**State Significant Development Application for Crown Sydney Hotel Resort  
(SSD 6957), 51a Hickson Road, Barangaroo – Response to Submissions**

Thank you for your letter dated 21 September 2015 requesting Transport for NSW (TfNSW) comment on the above Response to Submissions.

CD15/19107

Figure 25 Public Off-Street Car Parks

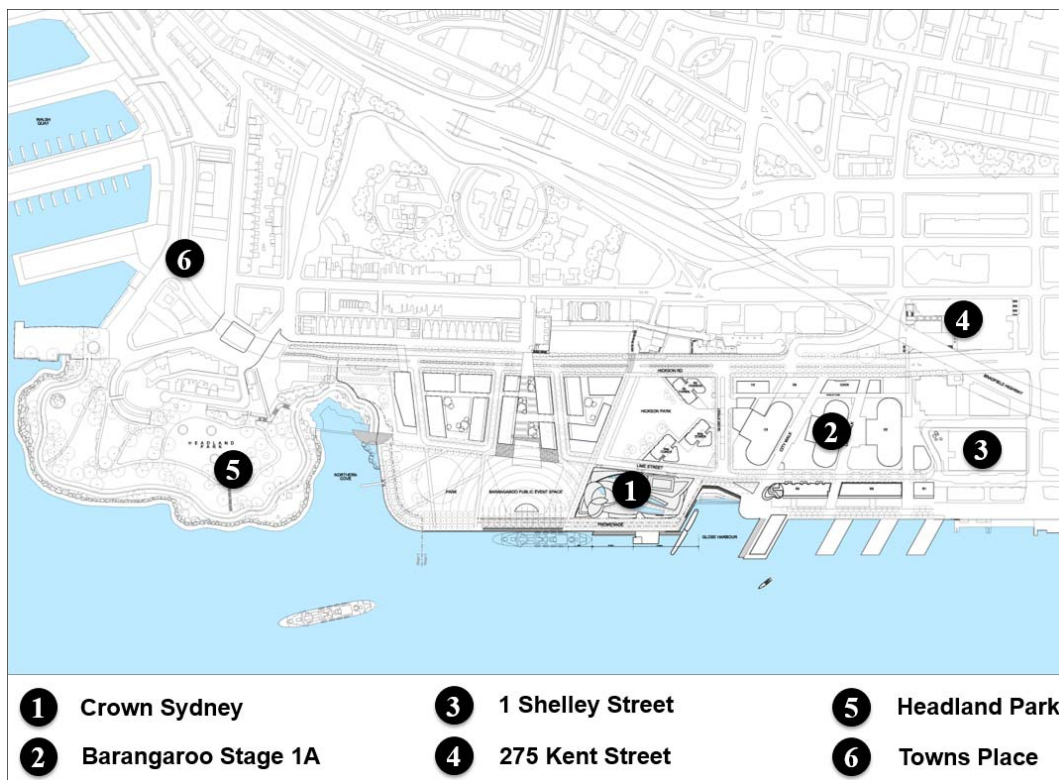
The TfNSW submission requested that the applicant undertakes a detailed analysis to demonstrate that 300 car parking spaces would be available for visitors to the Crown Hotel at the carparks located in the vicinity of the Barangaroo Precinct to accommodate the shortfall in hotel parking. However, there has been no quantitative analysis of capacity and demand of nearby car parks to take excess demand from the hotel in the Revised Transport Assessment Report. Therefore, TfNSW requests that the applicant undertakes a detailed parking assessment of nearby car parks that are expected to be used by hotel patrons.

The applicant shall undertake a detailed analysis to demonstrate that 300 car parking spaces would be available for visitors to the Crown Hotel at the carparks located in the vicinity of the Barangaroo Precinct to accommodate the shortfall in hotel parking. The detailed analysis shall include hourly demand and capacity of each car park in the vicinity of the Barangaroo Precinct for a week period.
